Development Facilitation Team (DFT) – Review Comments

Project No: PR-2021-005630 Date: 1/08/2025 Agenda Item: #5 Zone Atlas Page: P-9

Request: Waiver request to EV parking requirements for a new LIHTC Multi-Family Project

Project Name: 98th & Dennis Chavez (Ceja Vista)

OVERALL
SITE PLAN

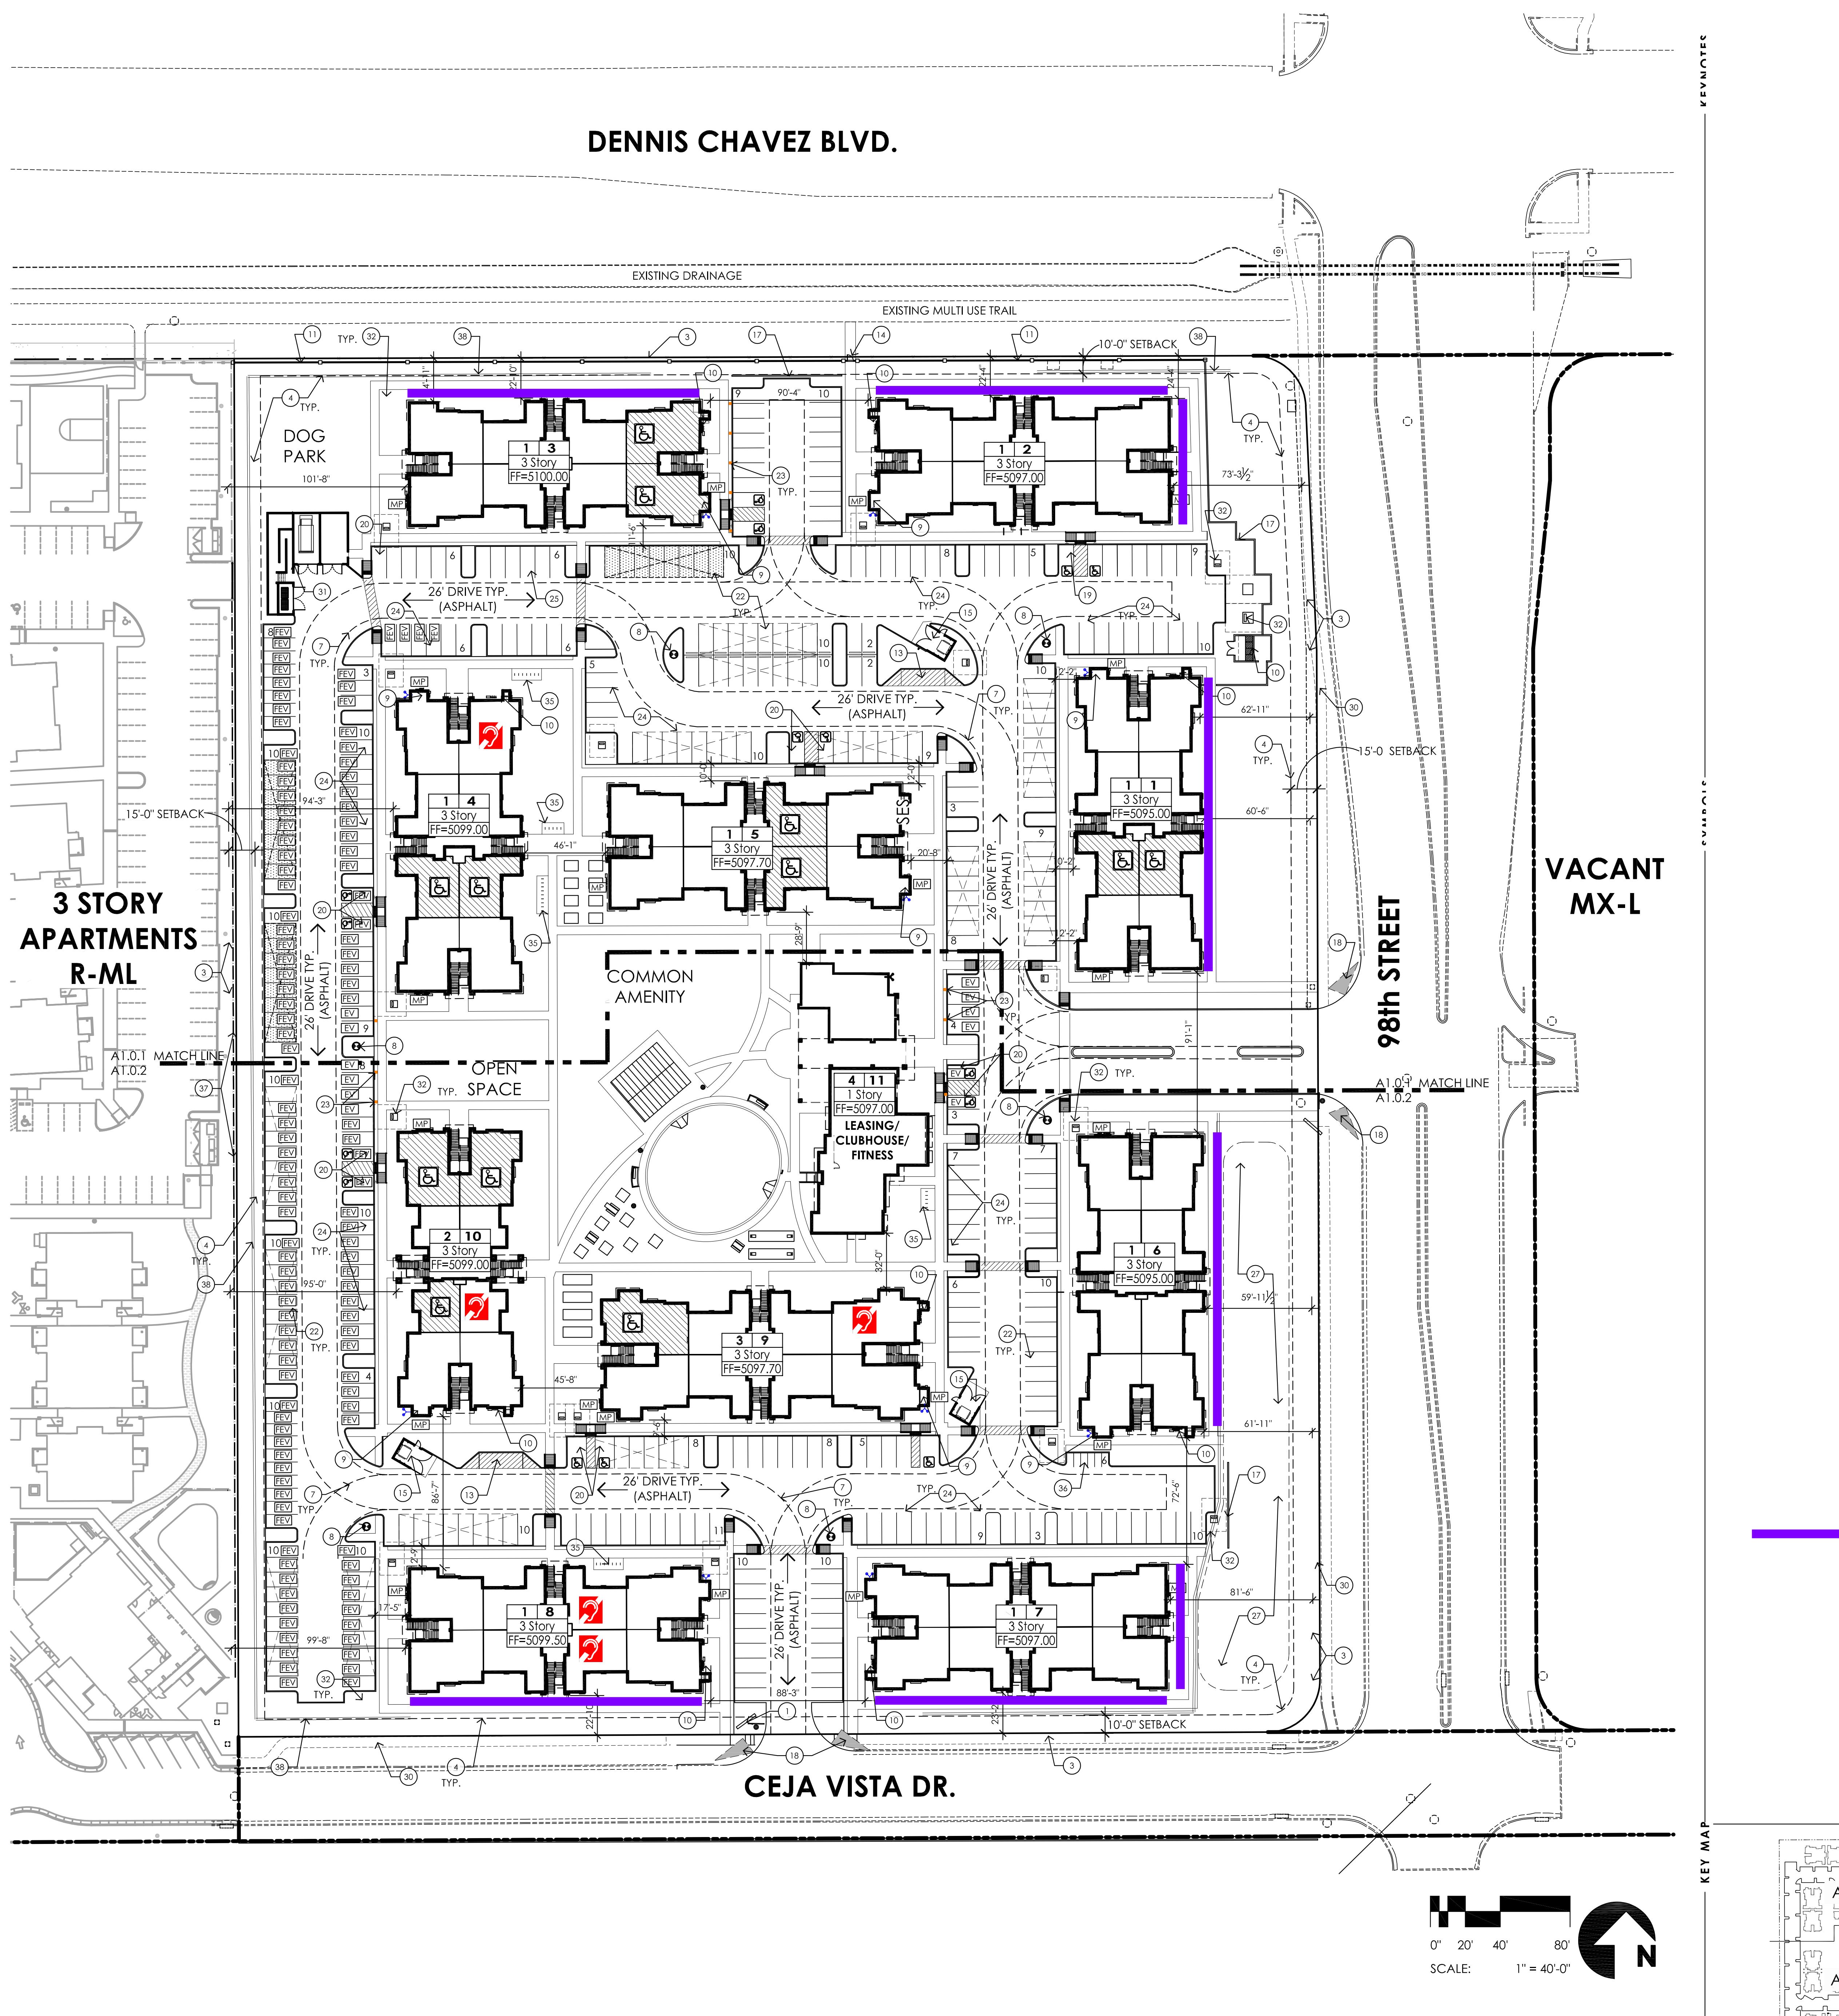
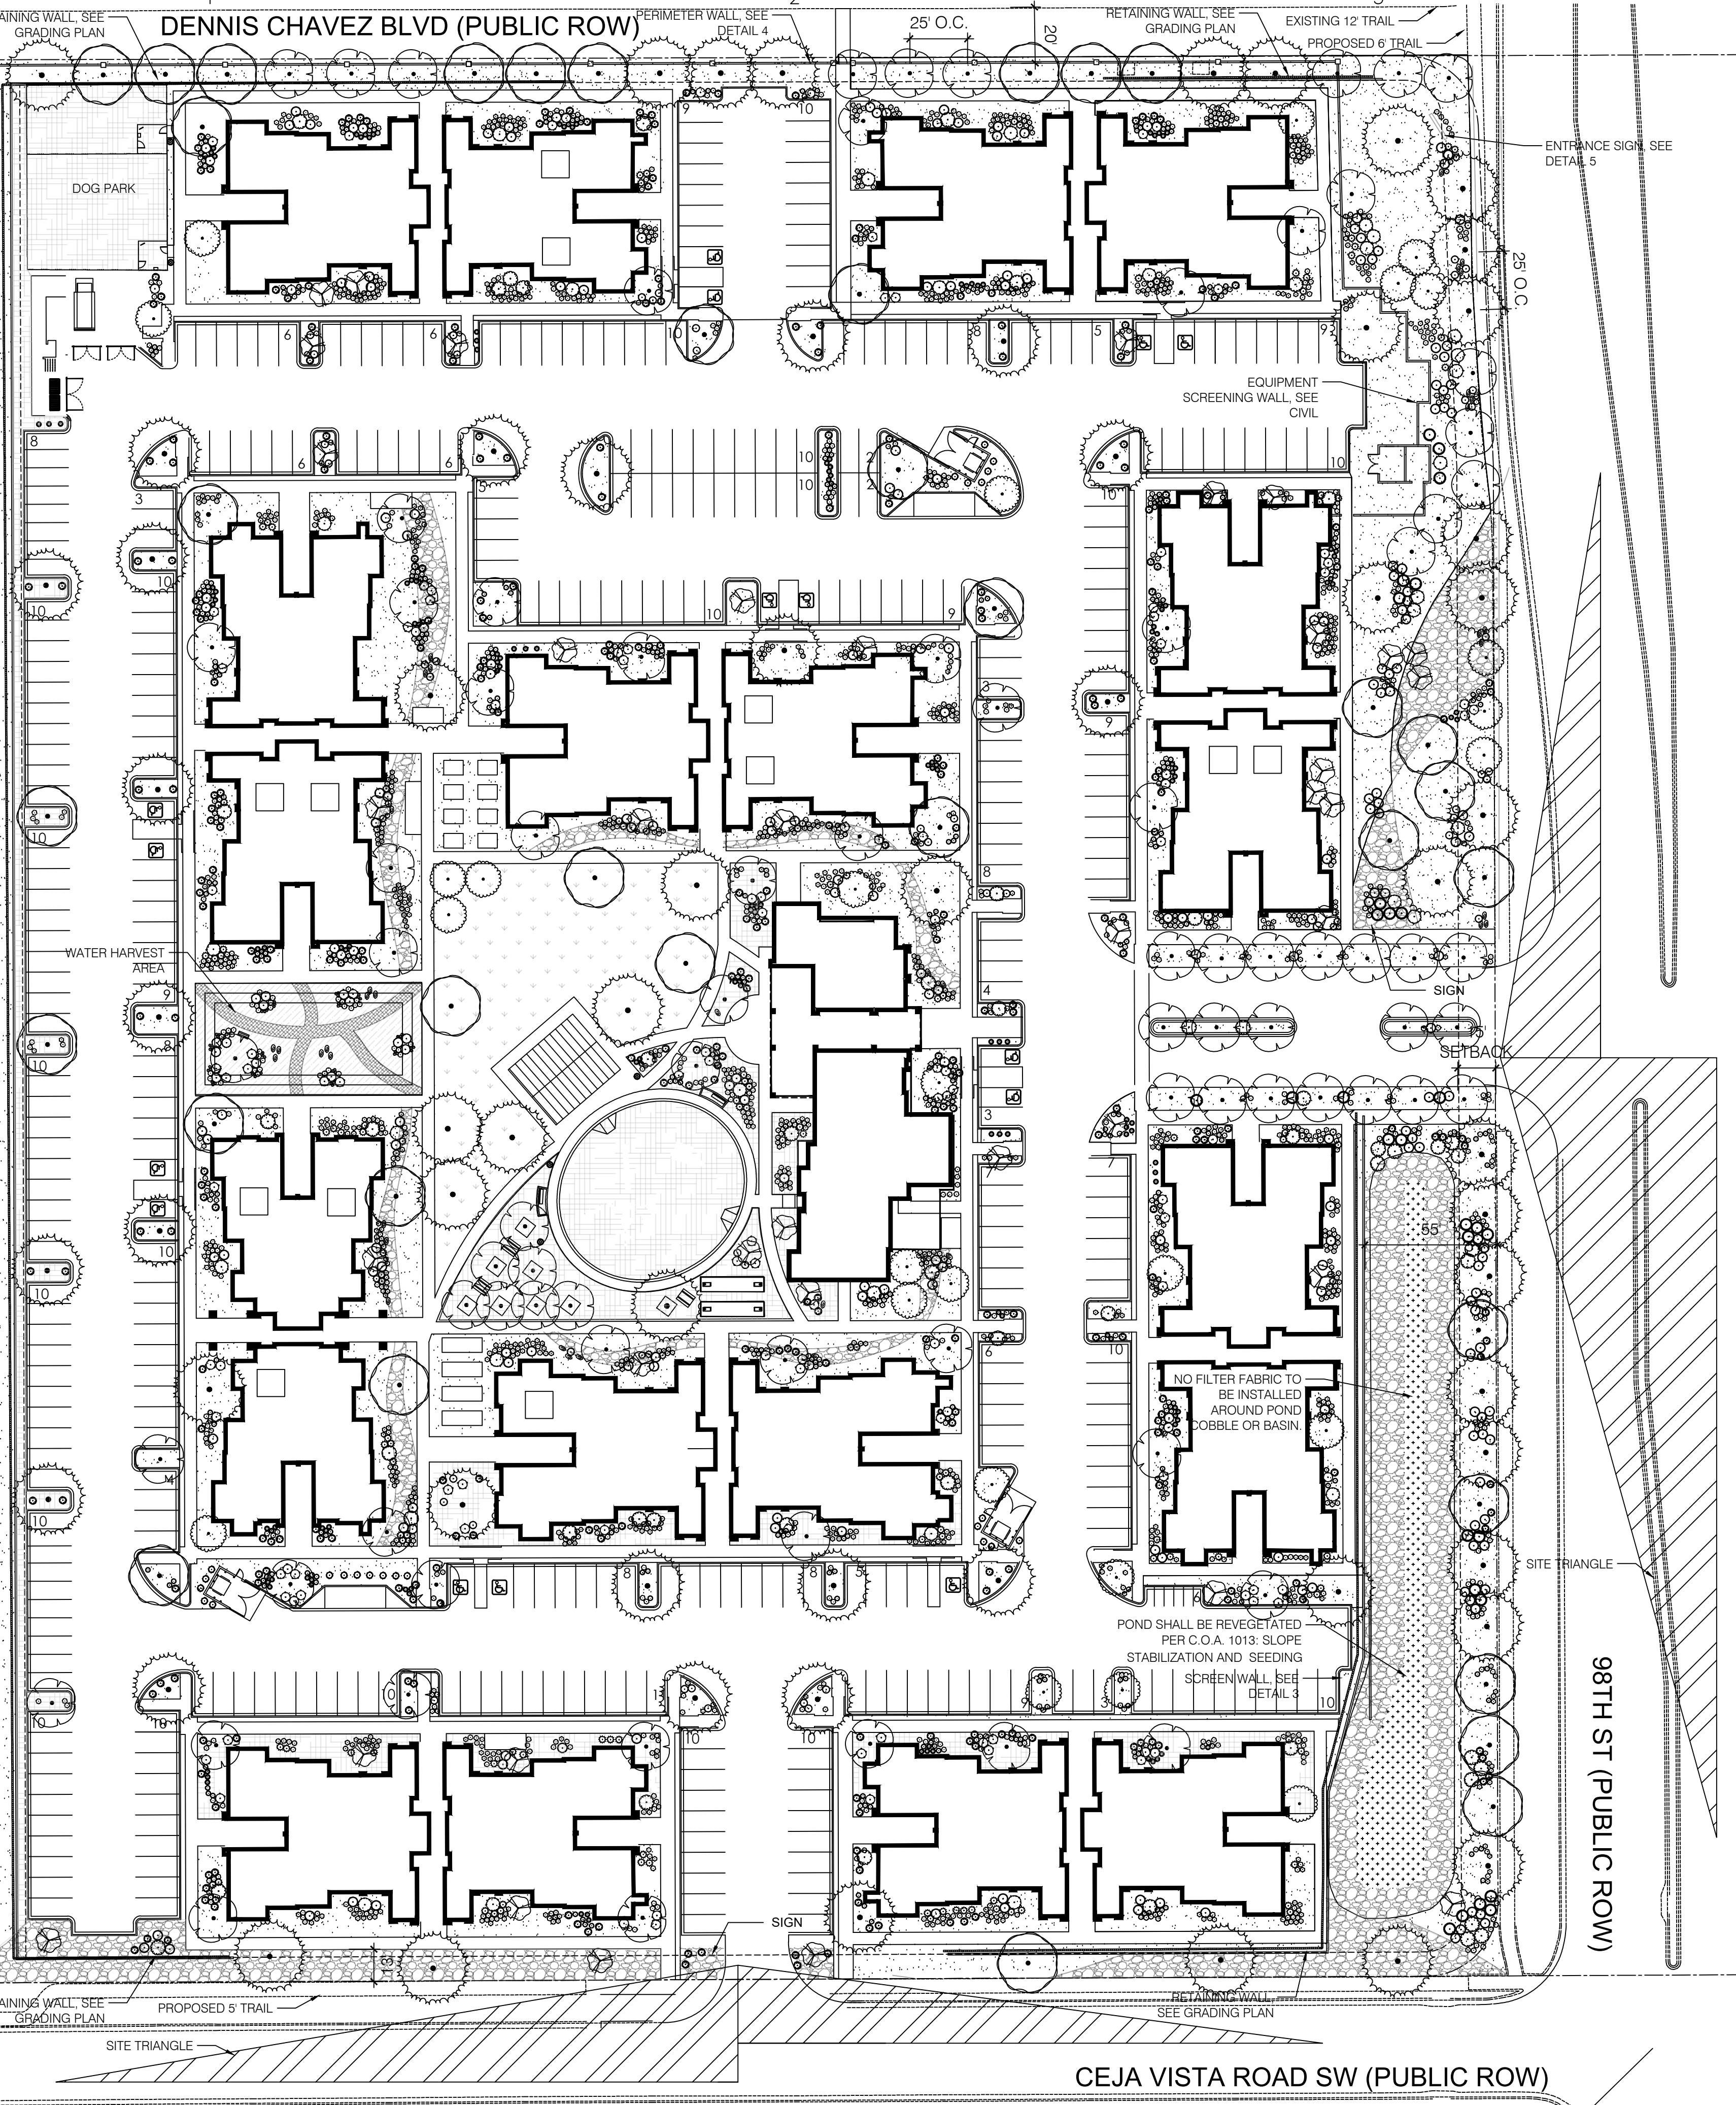
The required/Provided parking on the associated Site Plan is 405 spaces, including covered, uncovered, and EV-capable spaces. However, no EV Charging stations are provided, subject to this waiver request.

- Staff recommendation is to waive 8 of the required 20 EV Charging Station spaces, as the applicant must also meet the State Energy Code which requires at least 12 spaces for 240 dwelling units. Therefore, this waiver would not undermine the State Energy Code, which is adopted as the City's Energy Code.

- Provide the number of EV capable spaces that will be installed.

- Project and application numbers must be added to any associated IL attached to the Site Plan.
- Clarify if any of the EV installations will affect the IL on the associated Site Plan.
